November 13, 2013

RE: Applebee's at Holly Place

North Alb. Acres, Tract A, Unit B, Block 18, Lot 20 & Holly Place, Tract B
Conceptual Grading & Drainage Plan for Site Development Plan

BASIN MAP

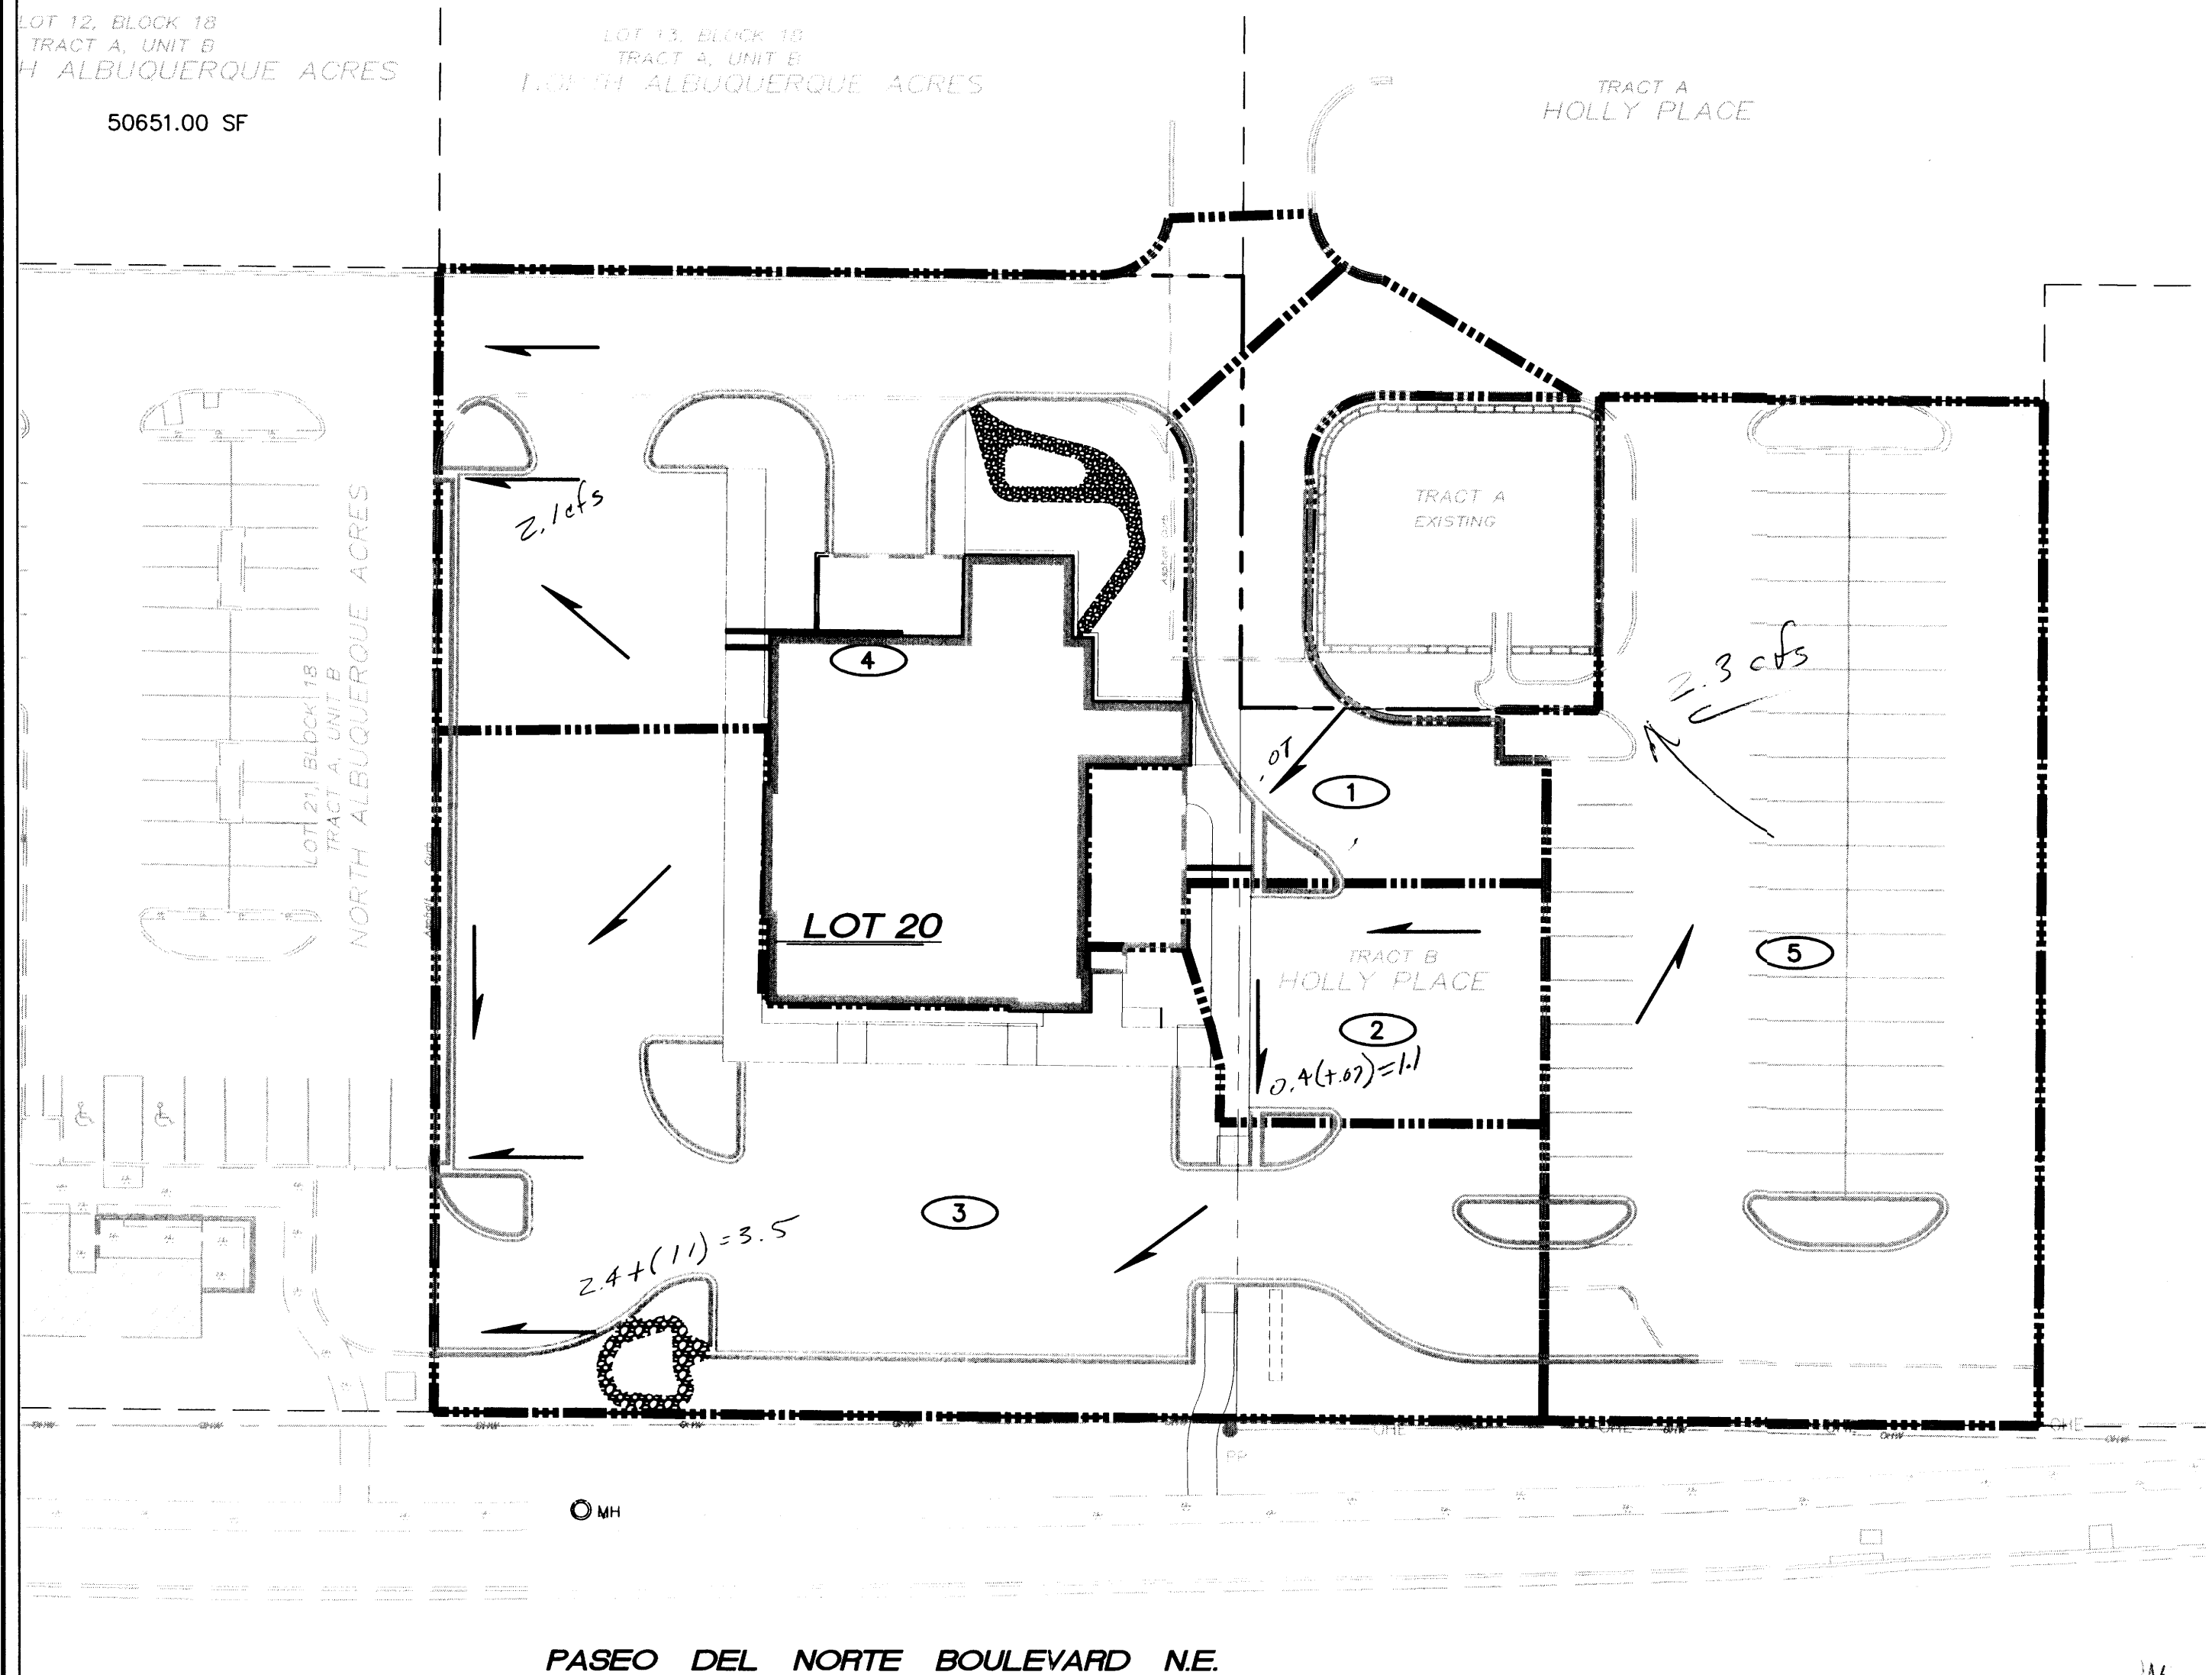
1. Ponding along the western edge of the site proposes rundown pipes that will be exposed above grade, west of the curb. Reference Detail 5 on Sheet CG-501. Stabilize this design for Building permit.
2. Clarify developed site flow conditions: On the Basin Map, label the new basin discharge points and rates at detention pond inlets and outlets, and where flows enter and leave the site.
3. Please advise your client that because this site exceeds 1.0 acre, any Grading or Building on this site will require a Storm Water Pollution Prevention Plan (SWPPP). Also, an Erosion and Sediment Control (ESC) Plan, prepared by a NM Registered Professional Engineer, must be submitted to and approved by this office, prior to Building Permit approval **and** start of grading.
